Supporting Statement for revised planning application at 2 Rosehill Avenue, Horsell, GU21 4SE

This statement is written with regard to the Case Officer's report regarding the previous application, PLAN/2023/0425

project: 2 Rosehill Avenue
 Horsell
 GU21 4SE
 title: Proposed Plans
 scale: 1:100
 drawing: 2216-05A

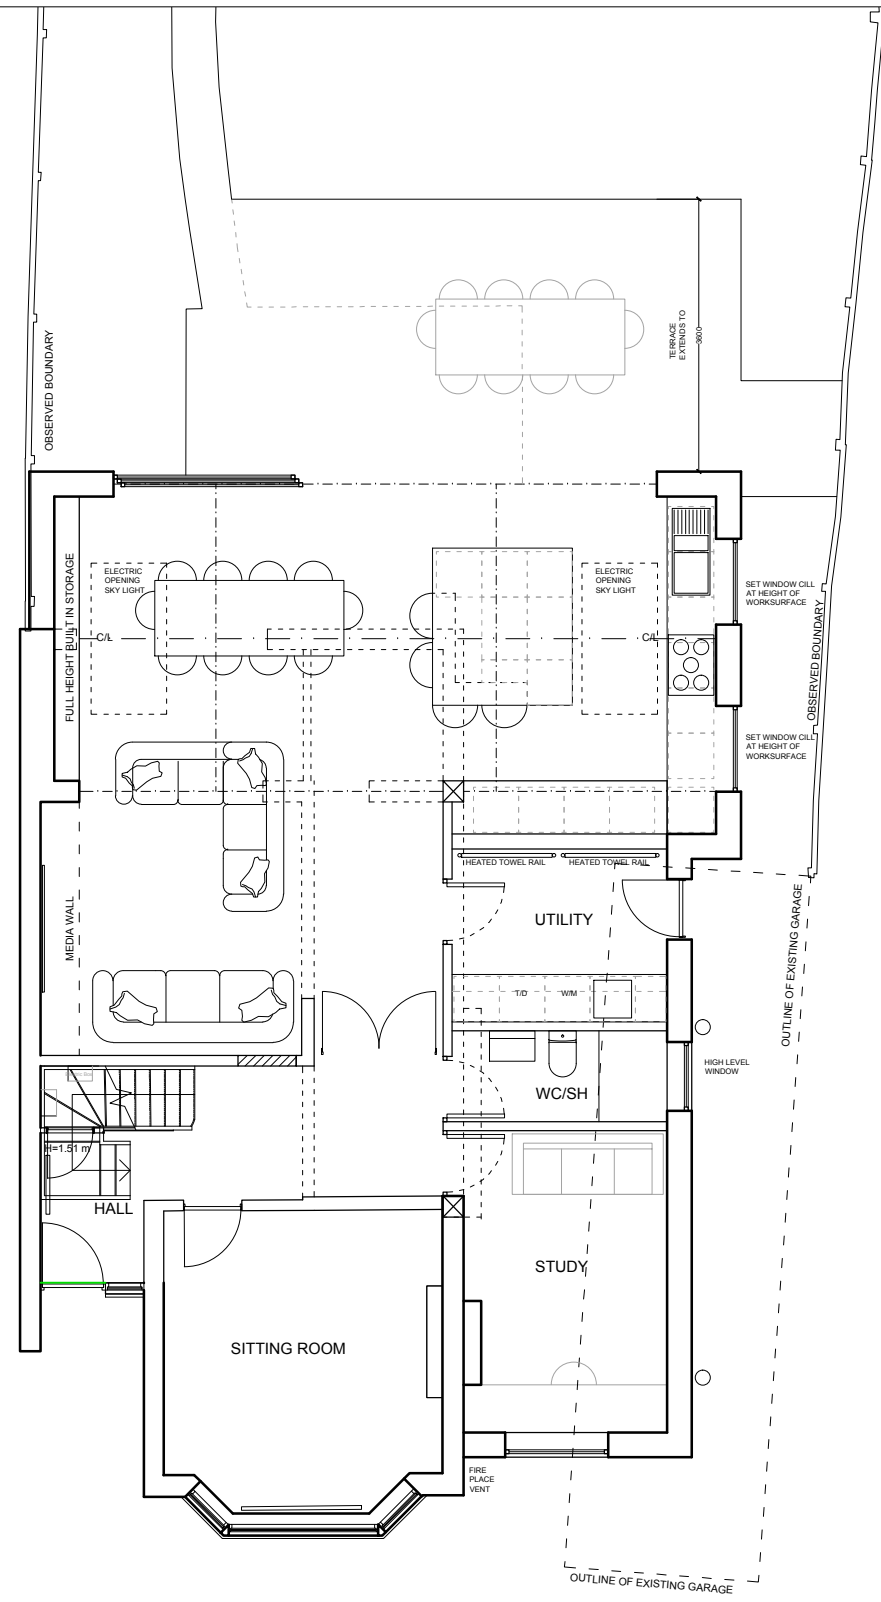
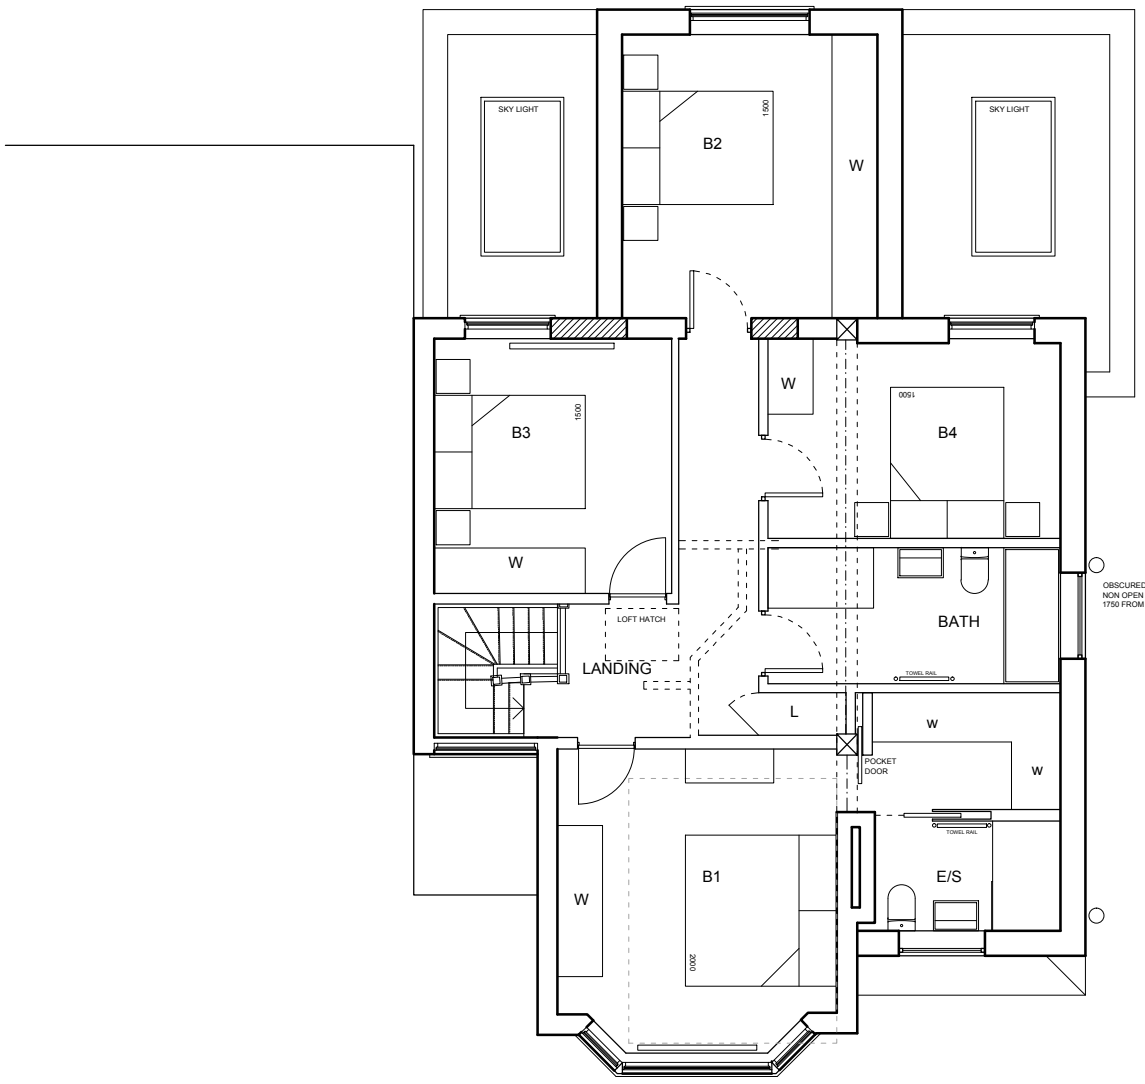
The report noted concerns regarding minimal setback from front elevation.

The scheme has been revised to increase the setback from the existing front elevation by

- Removing the proposed bay window
- Setting the first floor back
- Dropping the eaves line of the first floor
- Using a dormer window at first floor

project: 2 Rosehill Avenue
Horsell
GU21 4SE
title: Proposed Elevations 1|2
scale: 1:100
drawing: 2216-07A

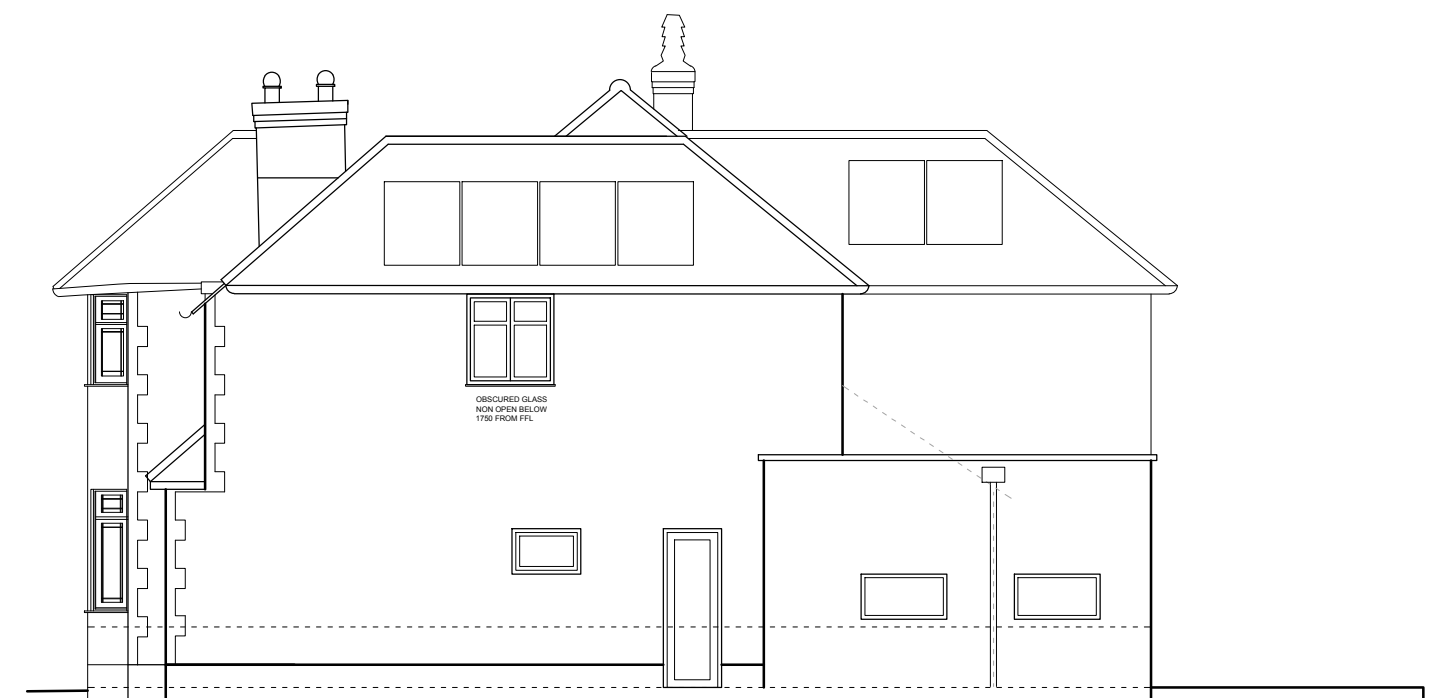
The report noted concerns regarding the extension of the overruling ridgeline.

The scheme has been revised to reduce the ridgeline of the proposed side extension below that of the front bay ridgeline, thus maintaining the prominence of the bay within the street scene.
